CDS is requesting comments on the following SEPA application: **SE-24-00010 Mallula-Dykes**. Links to the file materials can be found below. Kittitas County anticipates issuing an MDNS for this project application and is using the optional SEPA process. This may be the only opportunity to comment on the ecological impacts of this project.

TO: All Staff
FROM: Public Works Plan Review Team
DATE: March 14th, 2024
SUBJECT: SE-24-00010 Mallula-Dykes Public Works Comments

RE: SE-24-00010 – Mallula-Dykes Notice of Application
SR 903 milepost 6.45 Rt.

CONCEPTUAL SITE PLAN

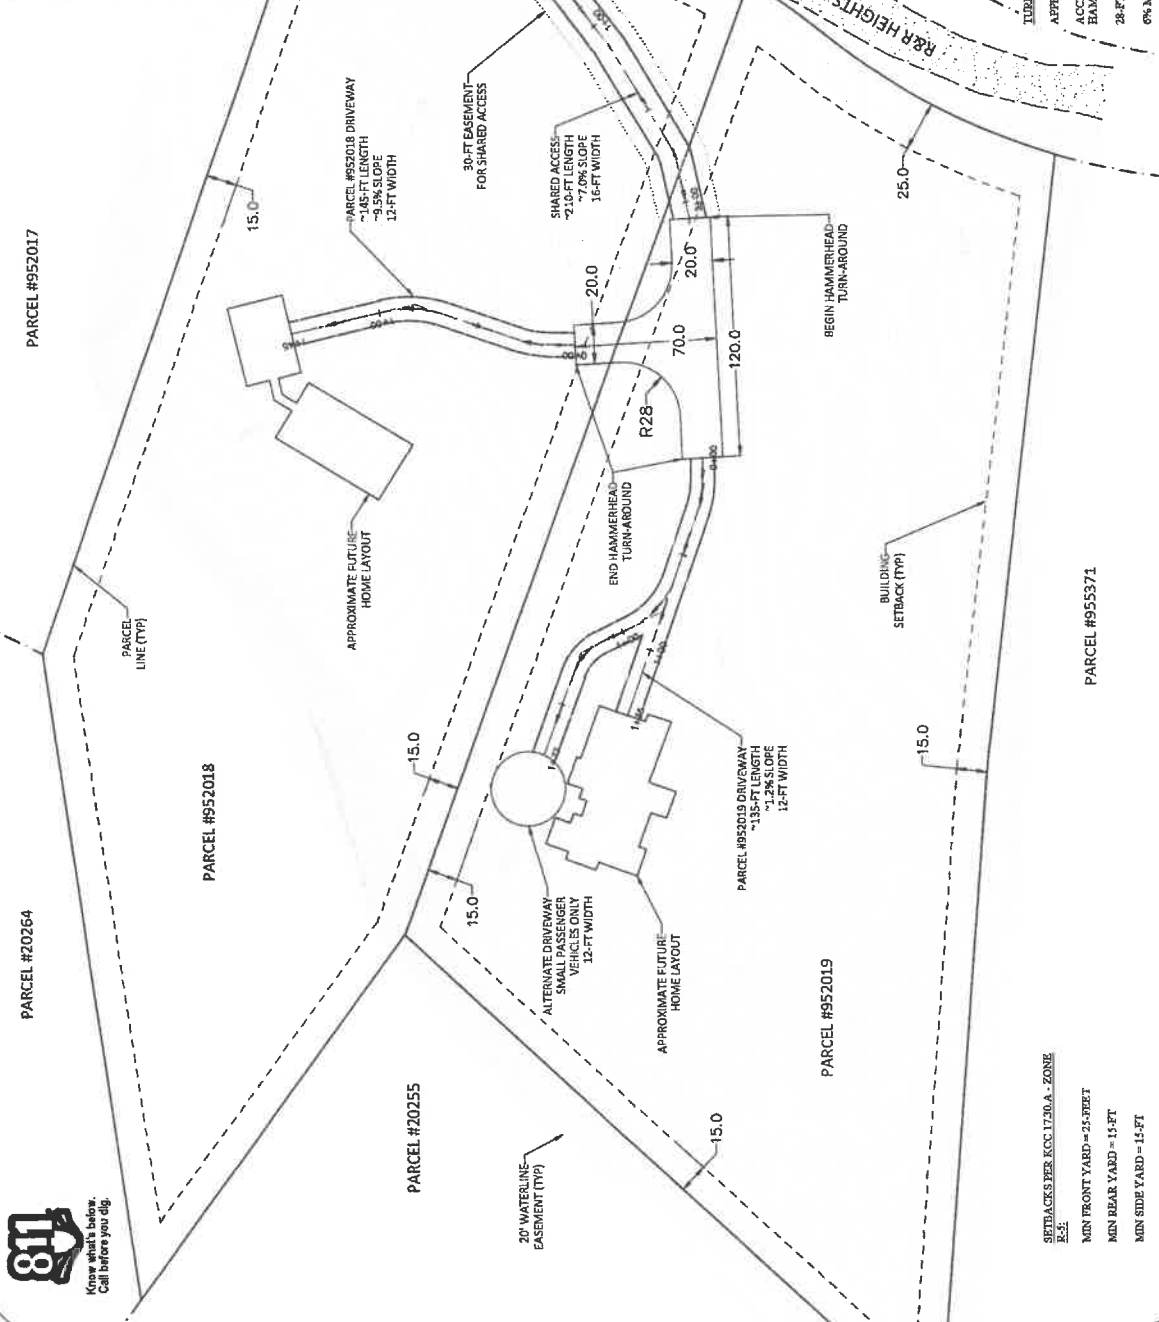
<p>ACCESS</p>	<ol style="list-style-type: none"> 1. Parcel 952018 has an issued access/address permit AA-23-00090 and parcel 952019 has an issued access/address permit AA-23-00087. A new site plan may be required if the project design has changed for the plans submitted with the access permit. Refer to Chapter 12 of the Kittitas County Code for access requirements. 2. Maintenance of driveway approaches shall be the responsibility of the owner whose property they serve. The County will not maintain accesses. 3. The access shall have a minimum width of 12' if the length of the driveway is less than 150', or 16' if the length of the driveway is more than 150'. 4. Accesses longer than 150' in length are required to provide a Fire Apparatus Road Turnaround meeting the requirements of Appendix D in the International Fire Code. 5. In addition to the above-mentioned conditions, all applicable Kittitas County Road Standards apply to this proposal. Access is not guaranteed to any existing or created parcels on this application. (TM)
